**CITY OF ALBUQUERQUE
PLANNING DEPARTMENT**

**February 1, 2012
DRB Comments**

PROJECT # 1009115

RE: Lots 8, 10 & 12, Livingston Place Subdivision

**Plat for
Lots 8-A and 10-A
Livingston Place**
Comprised of Lots 8, 10 and a
portion of 12, Livingston Place
City of Albuquerque
Bernalillo County, New Mexico
January 2012

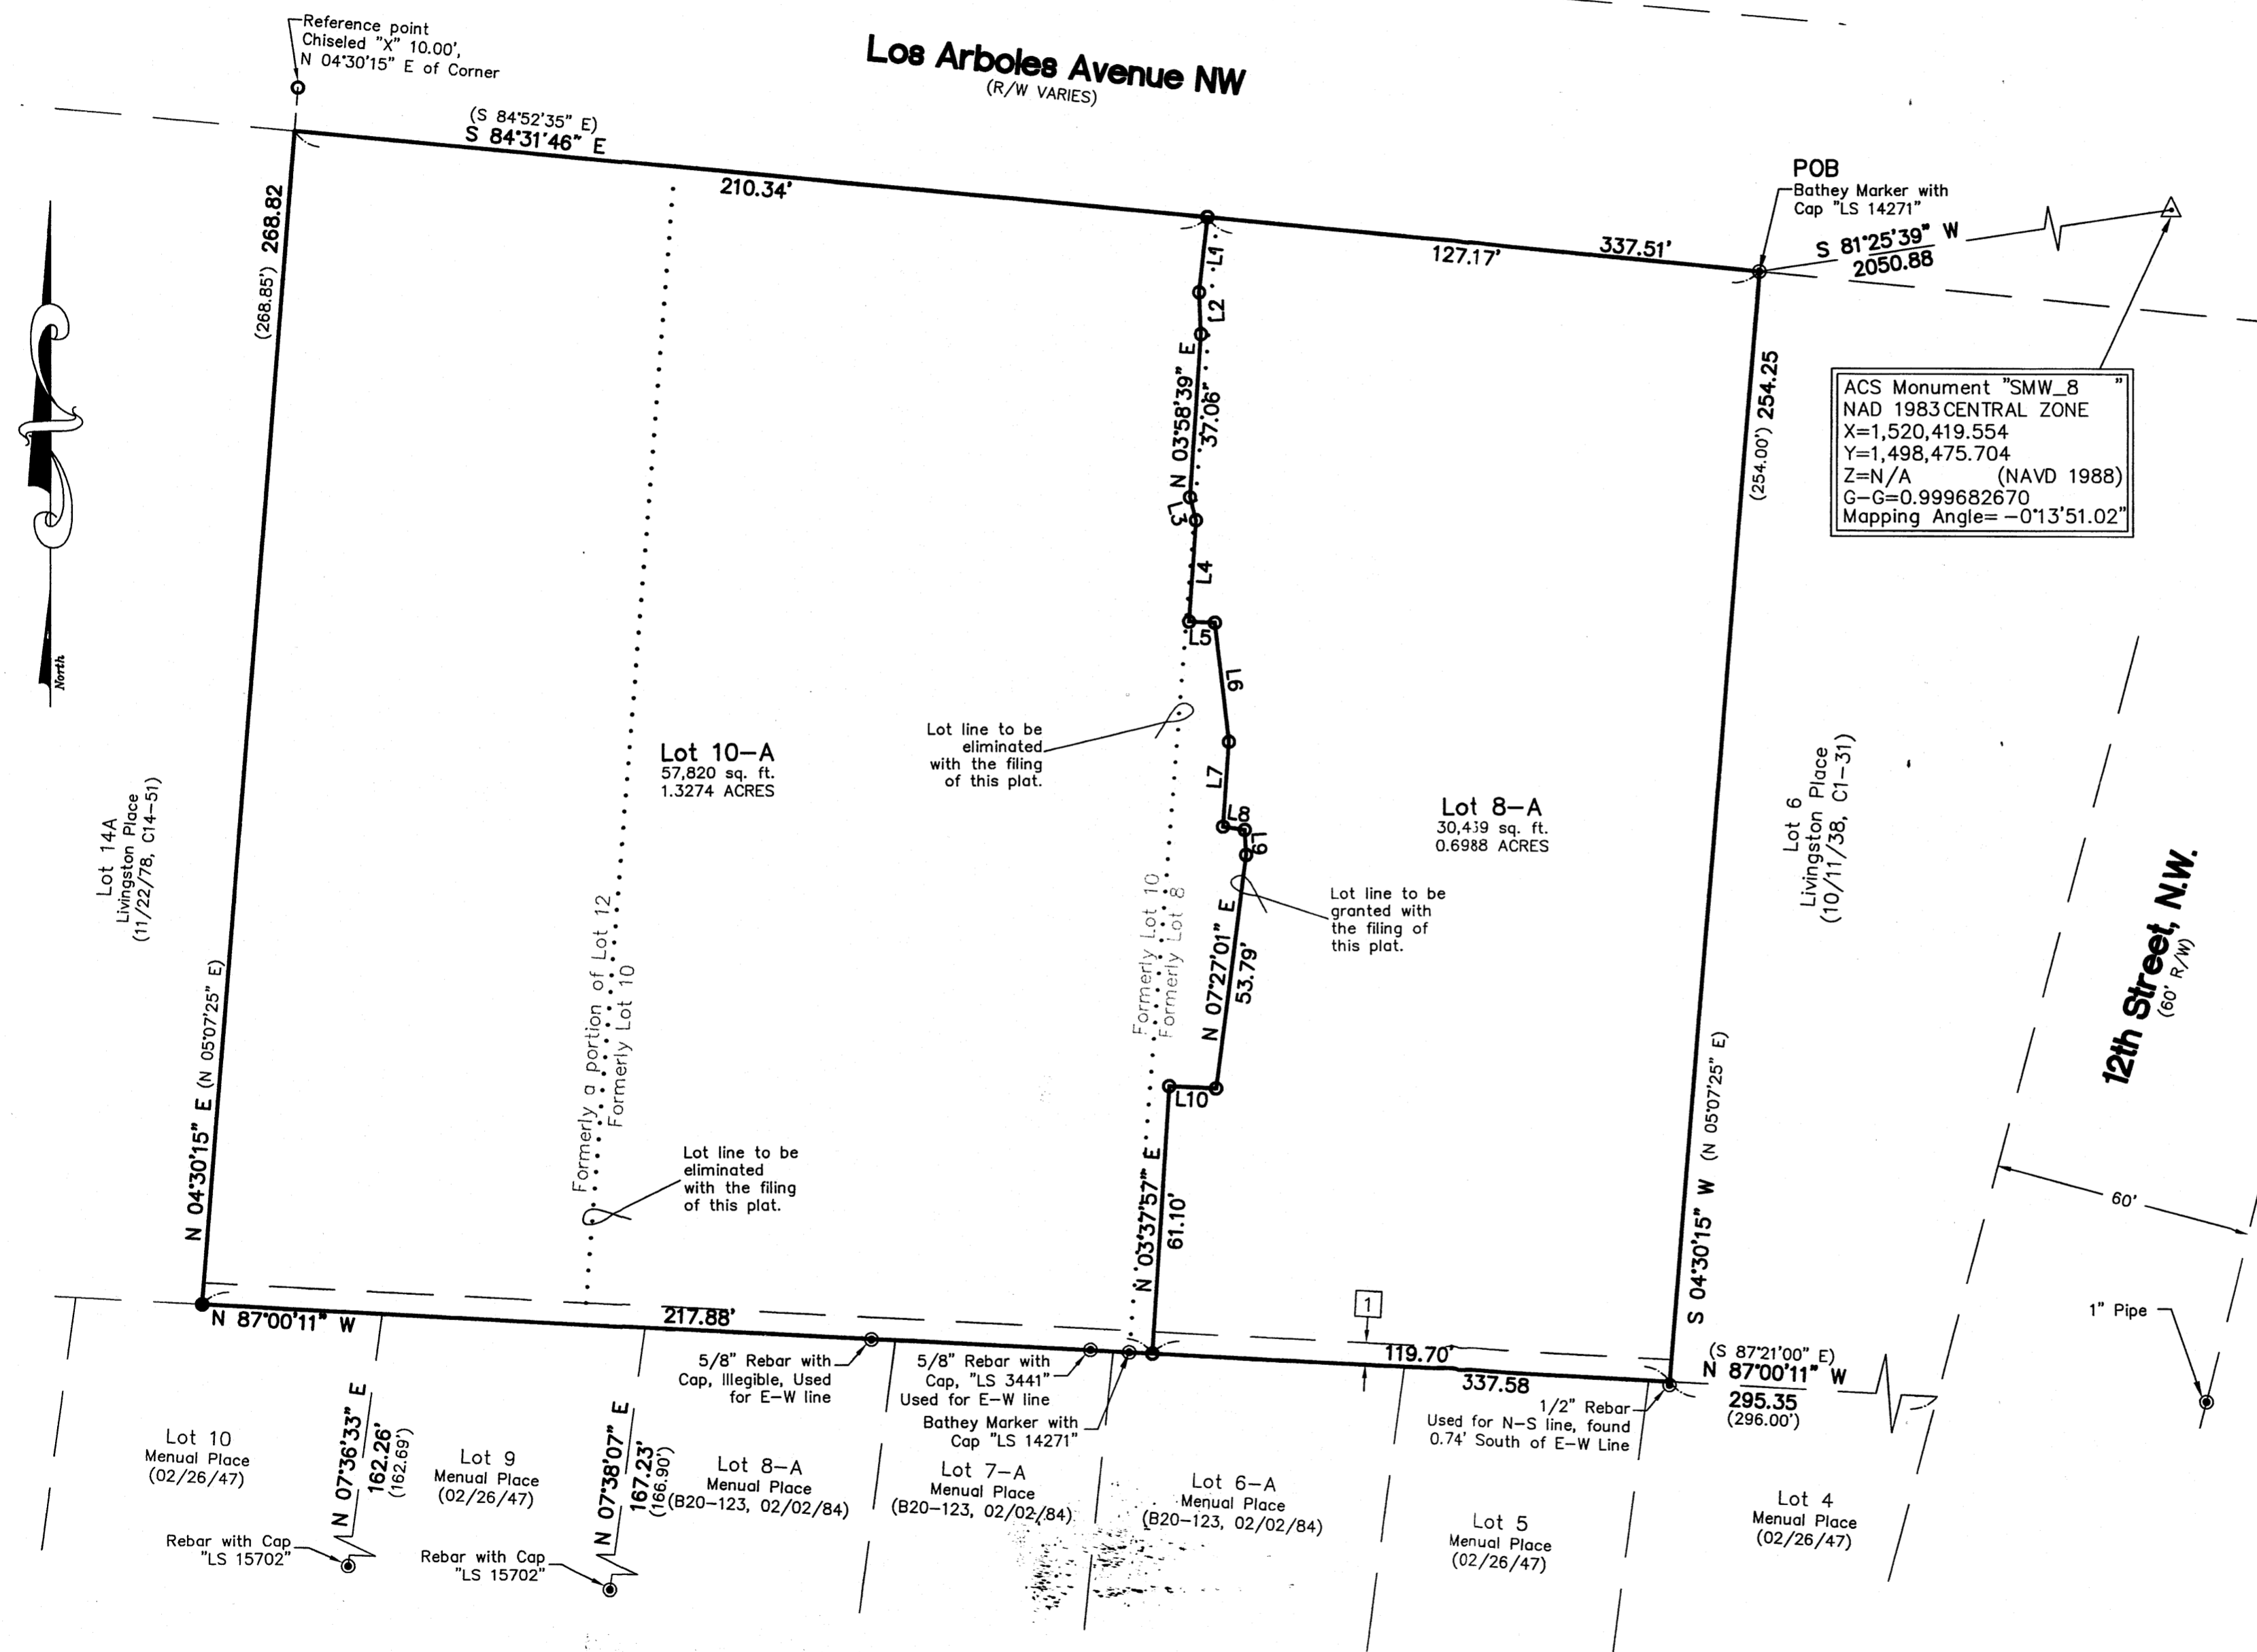
The common lot line between the two proposed lots does not conform the purpose and intent of the Subdivision Ordinance for harmonious and orderly development § 14-14-1-3 .
